CITY OF ALBUQUERQUE

March 3, 2020

Re: Monterey Place Apartments
2306-2320 Central Avenue SW
Traffic Circulation Layout
Engineer's/Architect's Stamp 02-11-20

Based upon the information provided in your submittal received 02-13-20, the above referenced plan cannot be approved for Building Permit until the following comments are addressed:

NOTES:

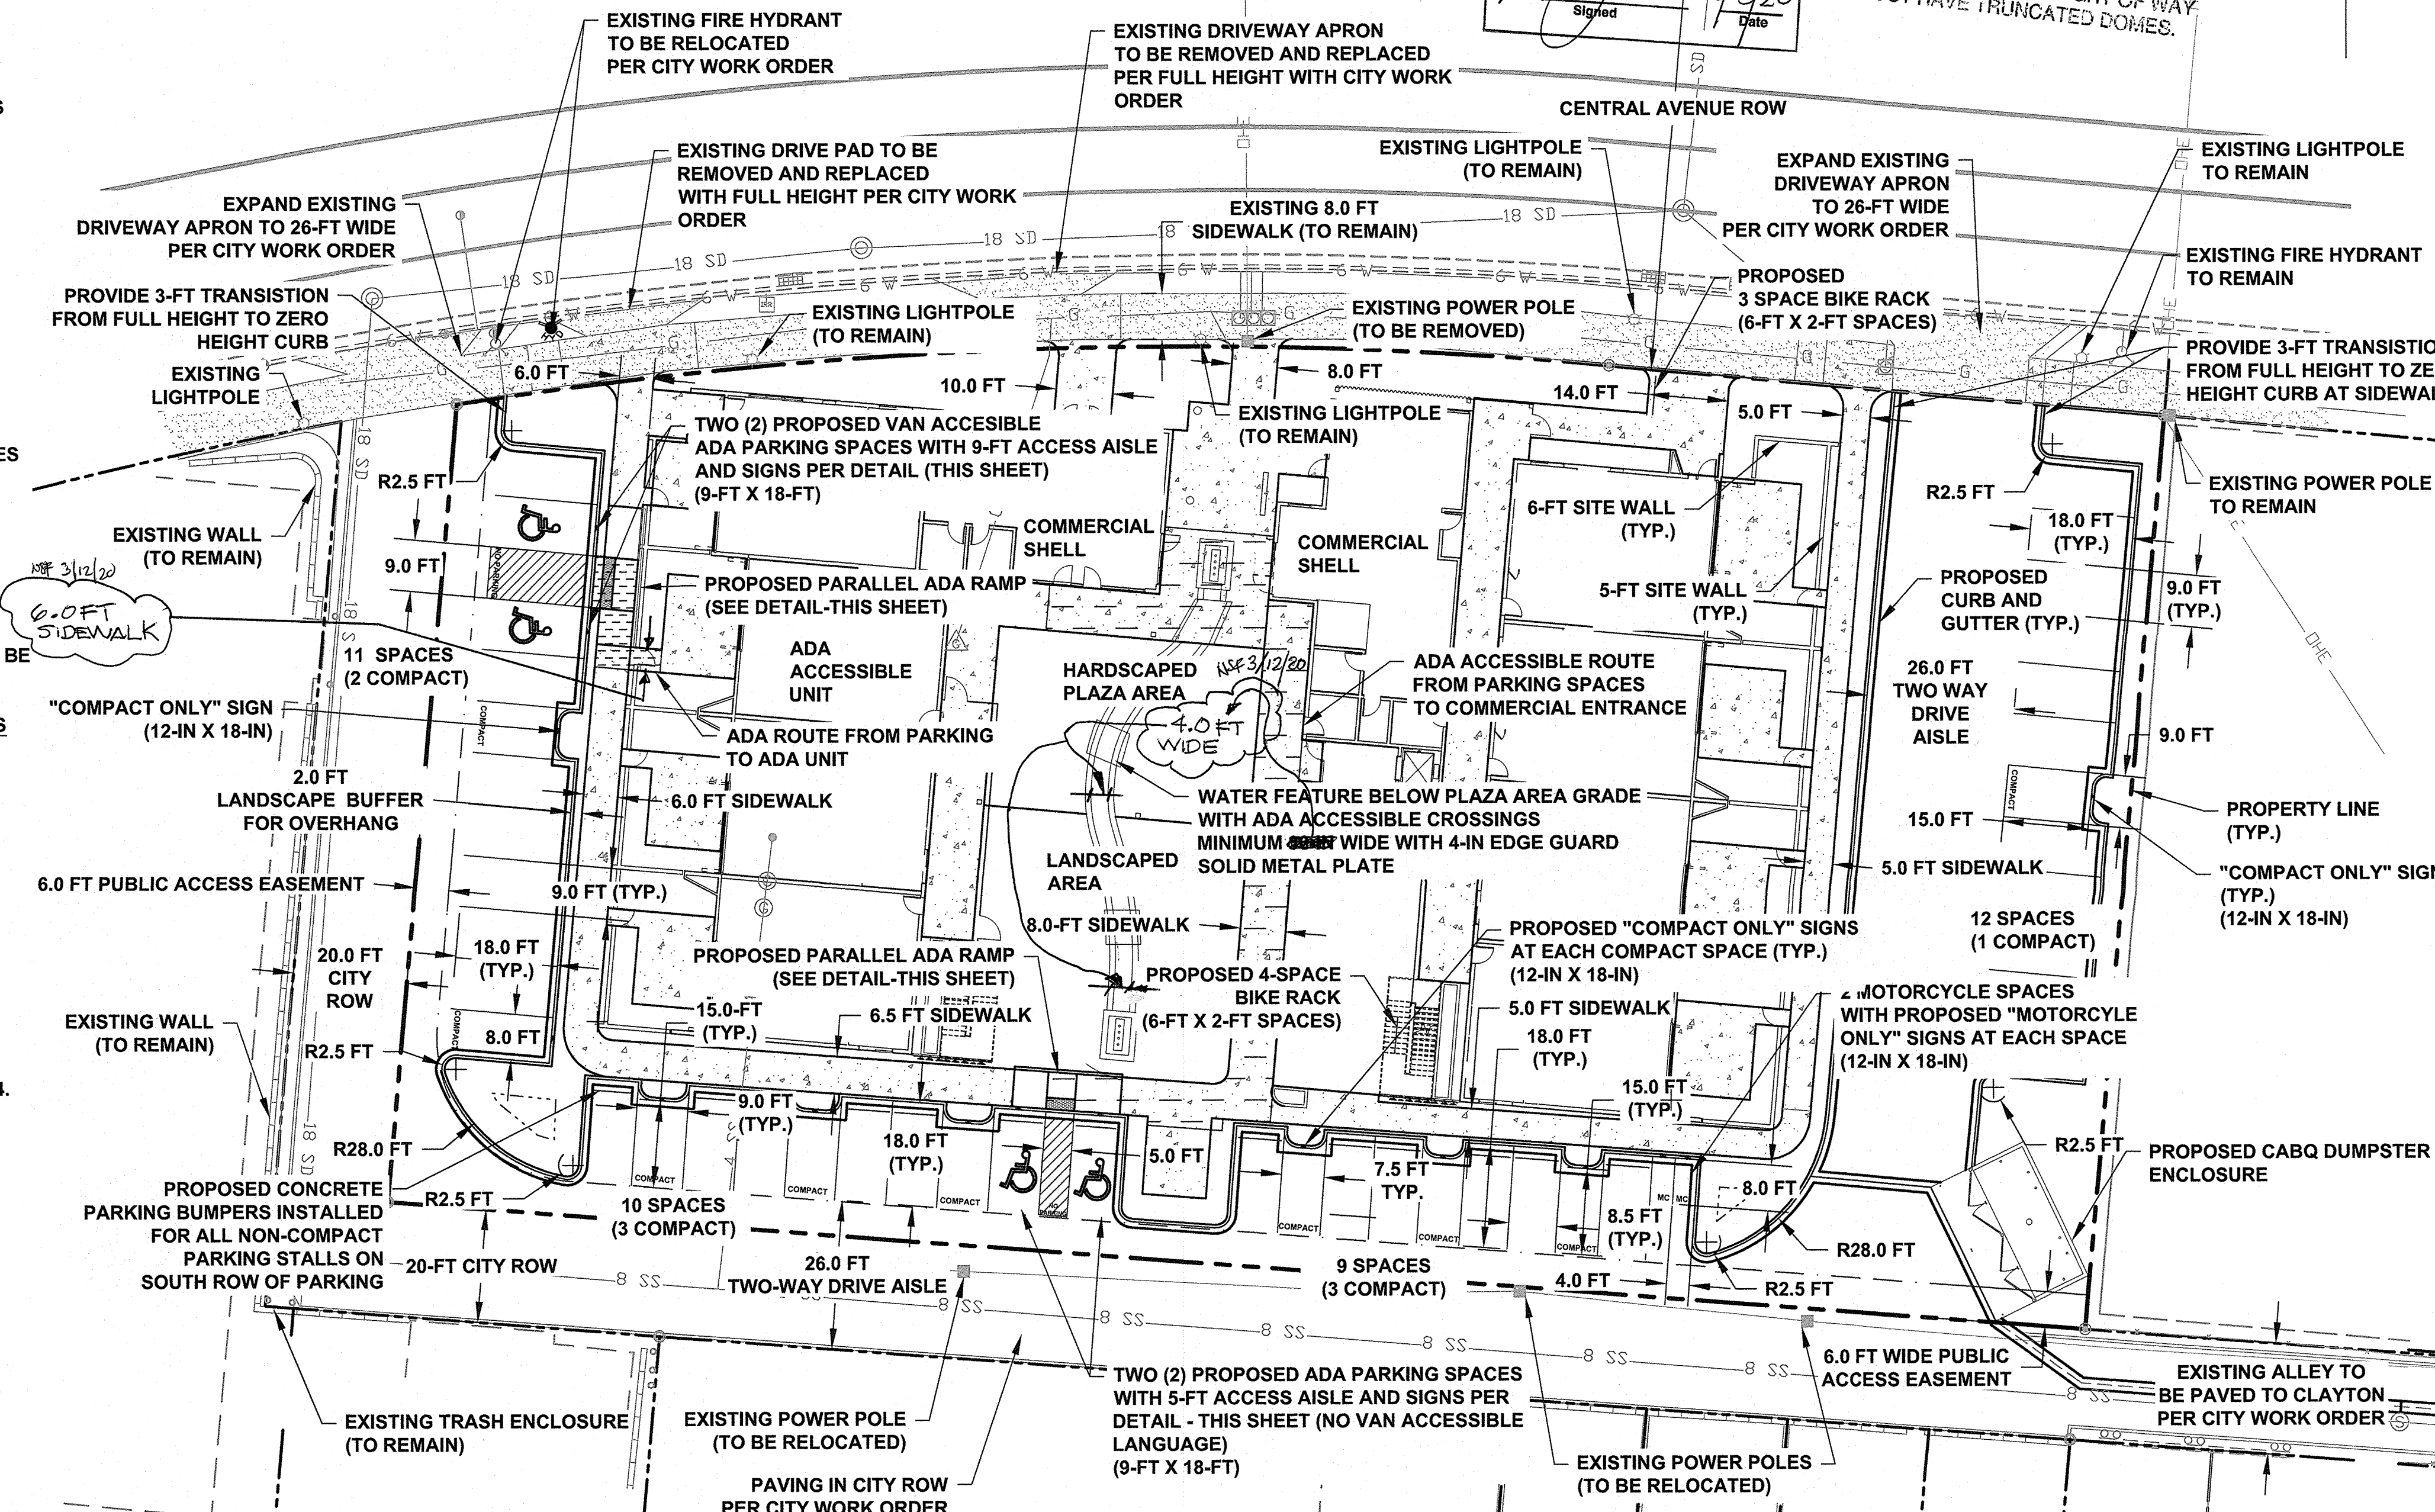
1. Please show a vicinity map showing the location of the development in relation to streets and well known landmarks.
2. Label any existing or proposed easements within the proposed development and access aisles.
3. Proposed number of parking spaces including bicycle and motorcycle parking need to be coordinated with Zoning to ensure compliance.
4. Please list the width and length for all proposed parking spaces. Some dimensions are not shown and provide landscaping buffer between curbing and sidewalk.
5. All proposed/existing entrance widths need to be shown on plans.
6. The minimum parking stall dimensions are:

7. The ADA accessible spaces must include an access aisle. Van accessible aisles should be 8ft wide; all others should be 5ft wide.

8. The ADA accessible parking sign must have the required language per 66-7-352.4C NMSA 1978 **"Violators Are Subject to a Fine and/or Towing."** Please call out detail and location of signs.

9. The ADA access aisles shall have the words **"NO PARKING"** in capital letters, each of which shall be at least one foot high and at least two inches wide, placed at the rear of the parking space so as to be close to where an adjacent vehicle's rear tire would be placed. (66-1-4.1.B NMSA 1978).

12. A detail of the water feature with ADA access crossings needs to be provided.
13. Motorcycle parking spaces shall be designated by its own conspicuously posted upright sign, either free-standing or wall mounted per the zoning code. Label MC on pavement of each space.

15. Bicycle racks shall be sturdy and anchored to a concrete pad. Show location of the bicycle racks.
16. A 1-foot clear zone around the bicycle parking stall shall be provided.

17. Bicycle parking spaces shall be at least 6 feet long and 2 feet wide.
18. Per the IDO, a 6 ft. wide ADA accessible pedestrian pathway is required from the public sidewalk to the building entrances. Please clearly show this pathway and provide details.

19. Per DPM, a 6 ft. wide ADA accessible pedestrian pathway is required from the ADA parking stall access aisles to the building entrances. Please clearly show this pathway and provide details.

20. Provide 8 ft. wide sidewalk when stalls are overhanging sidewalk. A solution would be to show parking bumpers on the south side parking stall.
